Subject: BE/160/21/DOC Land At Salt Box West Of Shripney Road Bognor Regis PO22 9NW

Drainage Engineer

DRAWING NO. (PROJECT CODE-ORIGINATOR-ZONE-LEVEL-TYPE-ROLE-NUMBER) SAL-HYD-PH2-ZZ-DR-C-7012					REVISION C03

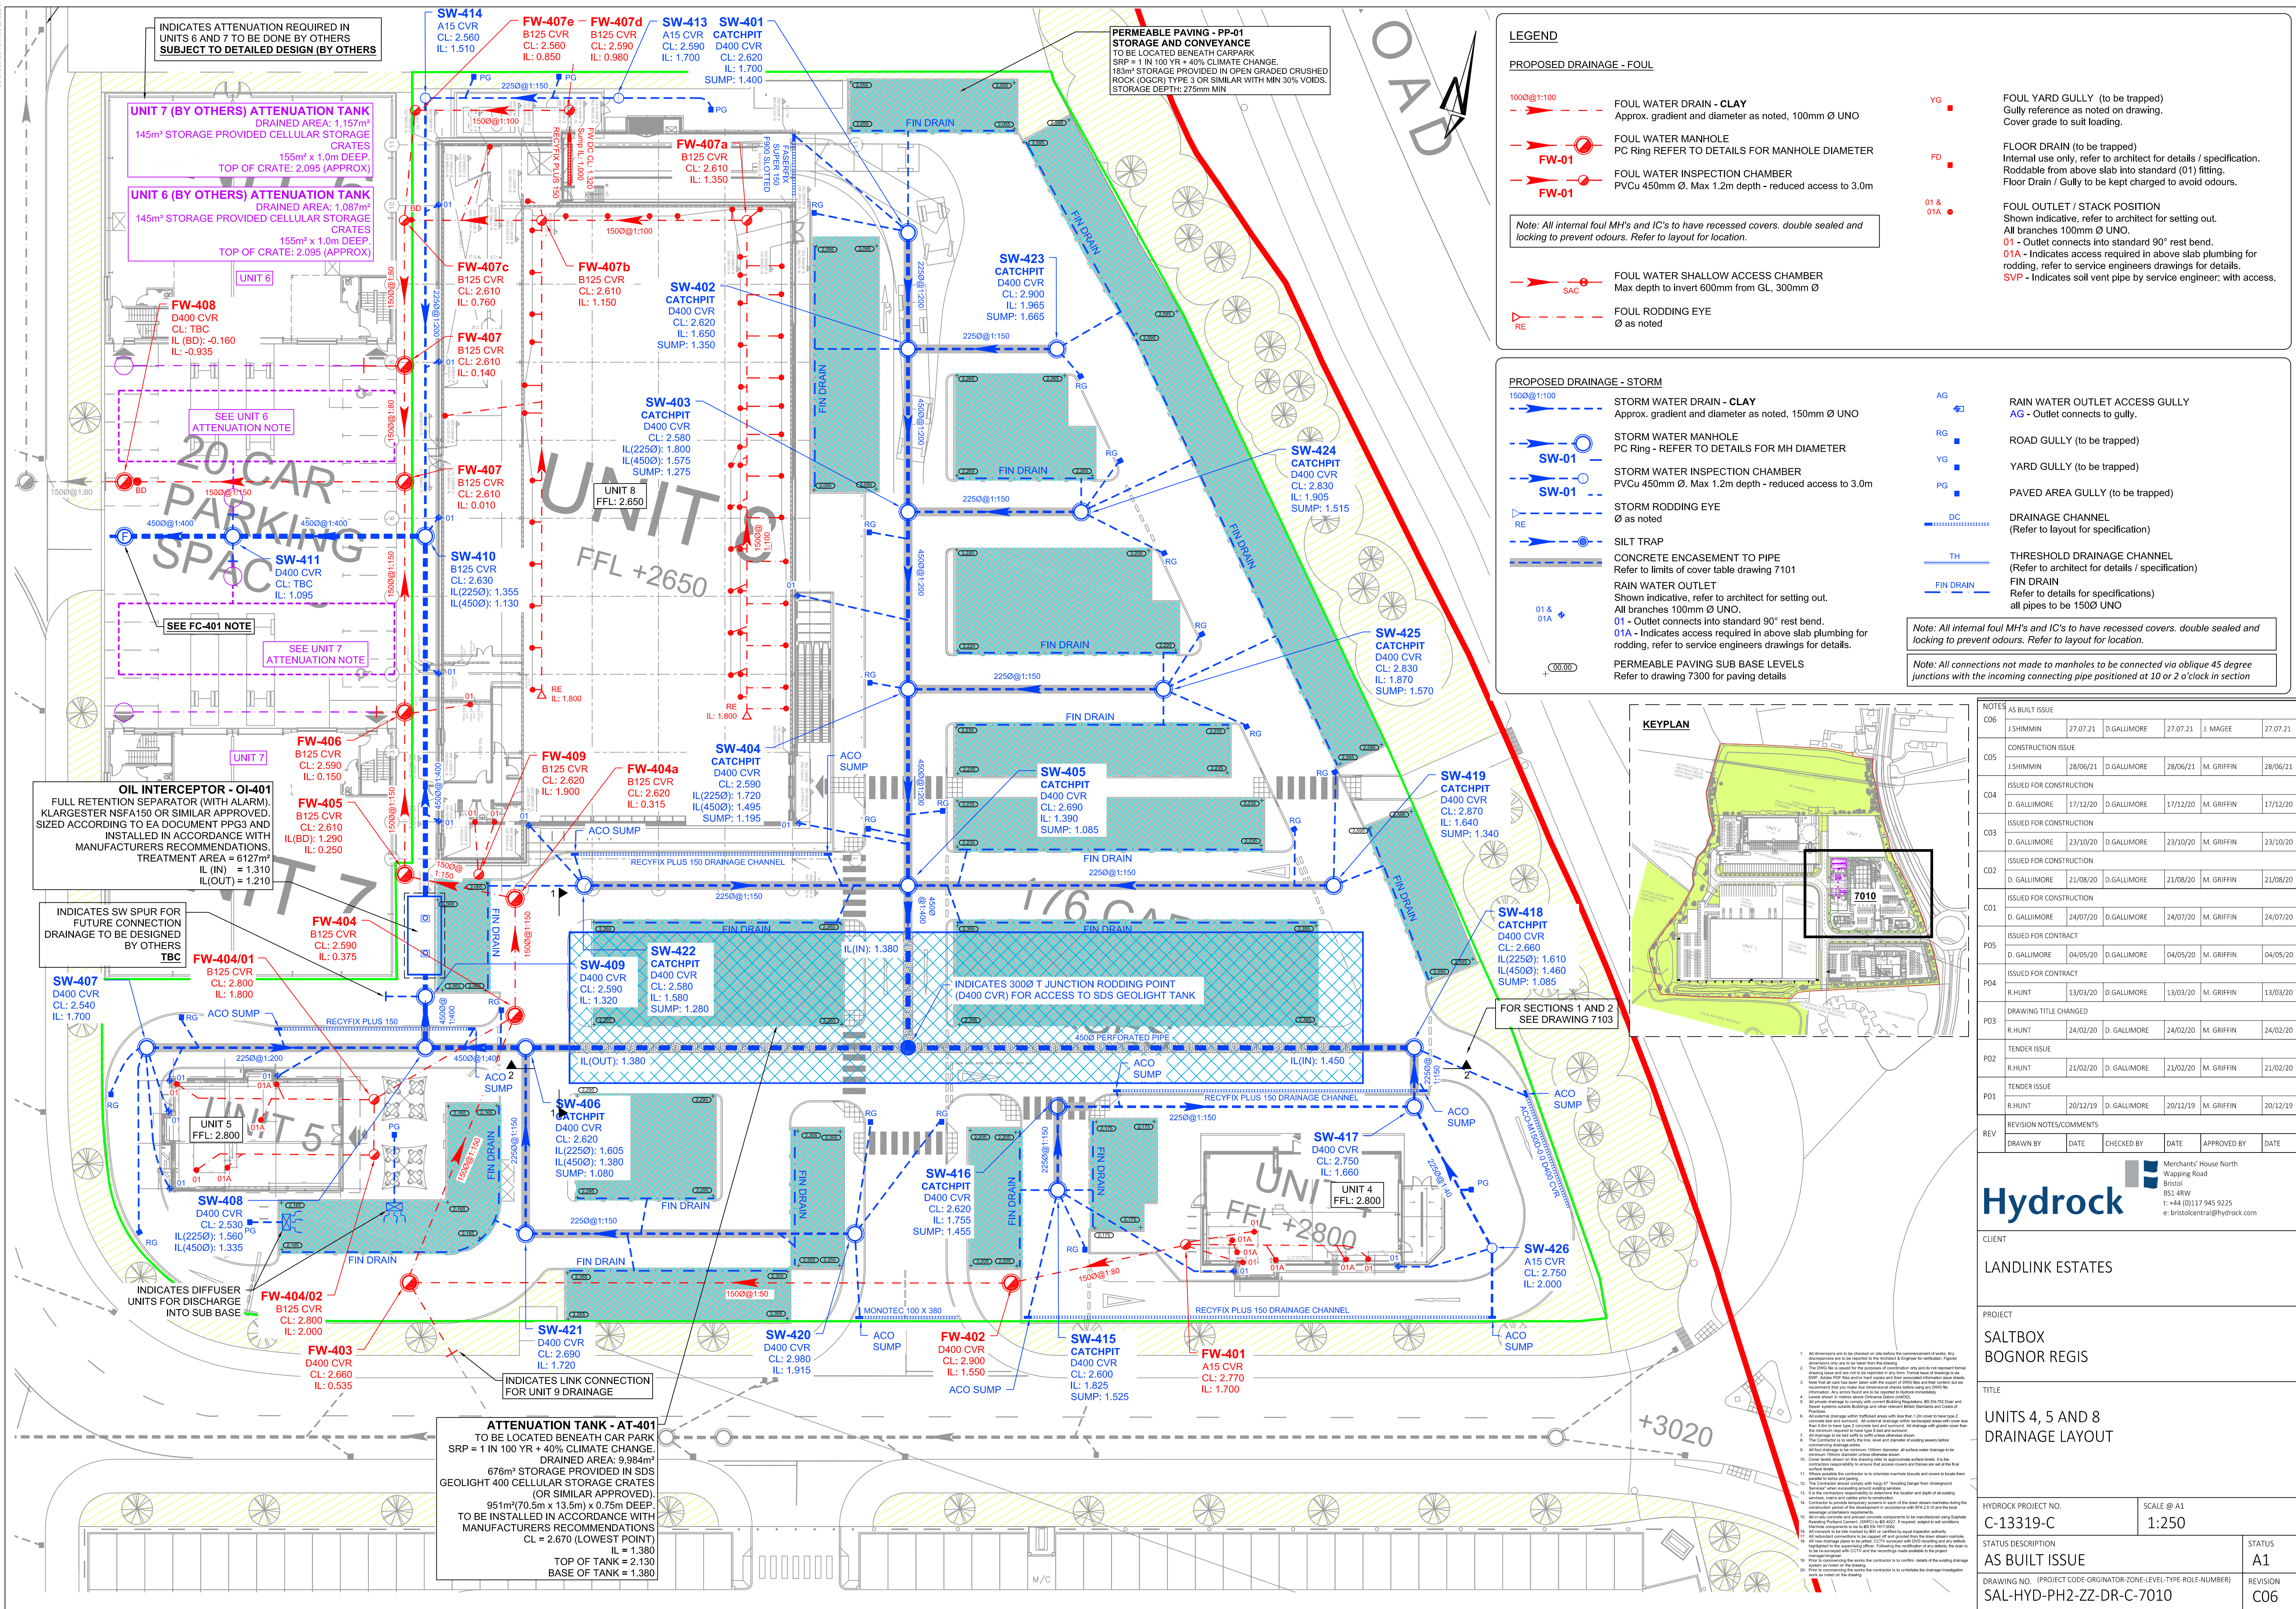
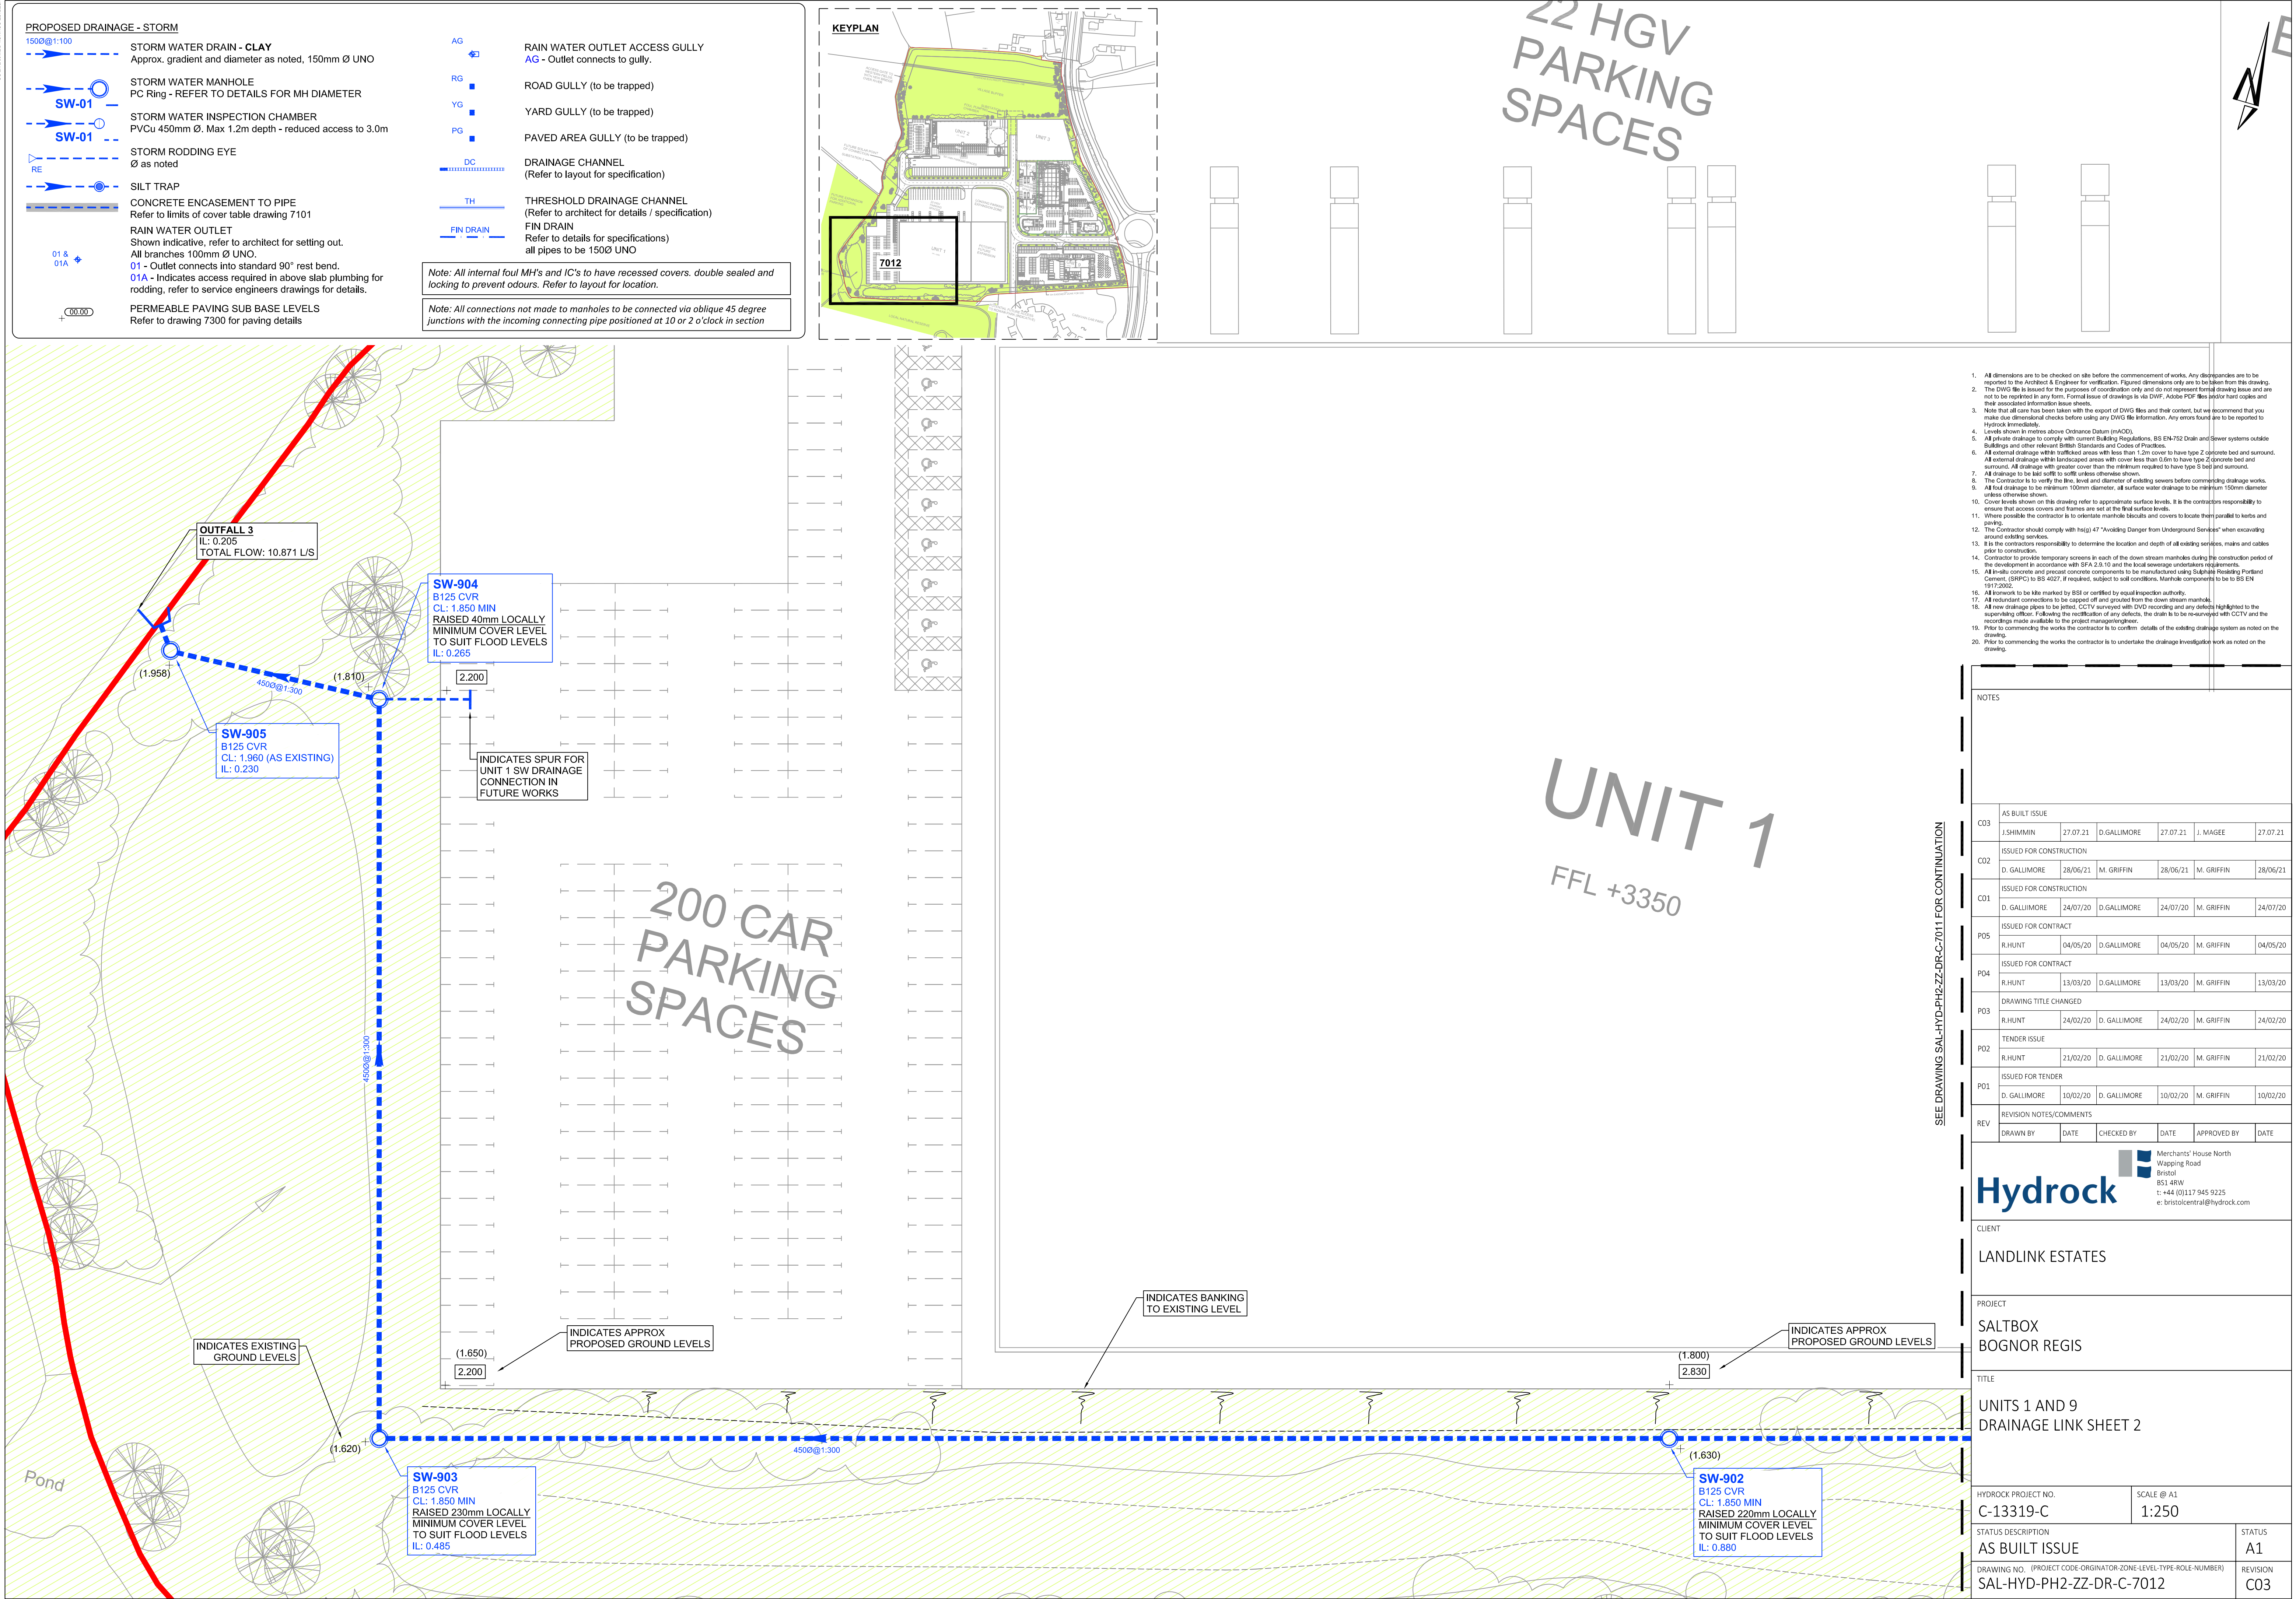
I have reviewed the pipes downstream of 503. There does not appear to be scope within the layout to relay the pipe downstream of 503 to achieve 1m/s self-cleansing velocity without completing significant work downstream. We would suggest that the maintenance manual is updated to increase the maintenance frequency of catchpits and pipework within this network.

There are other pipes within the network which are also slack, we would therefore recommend site wide increases in maintenance frequency.

Please can an updated maintenance manual be supplied.
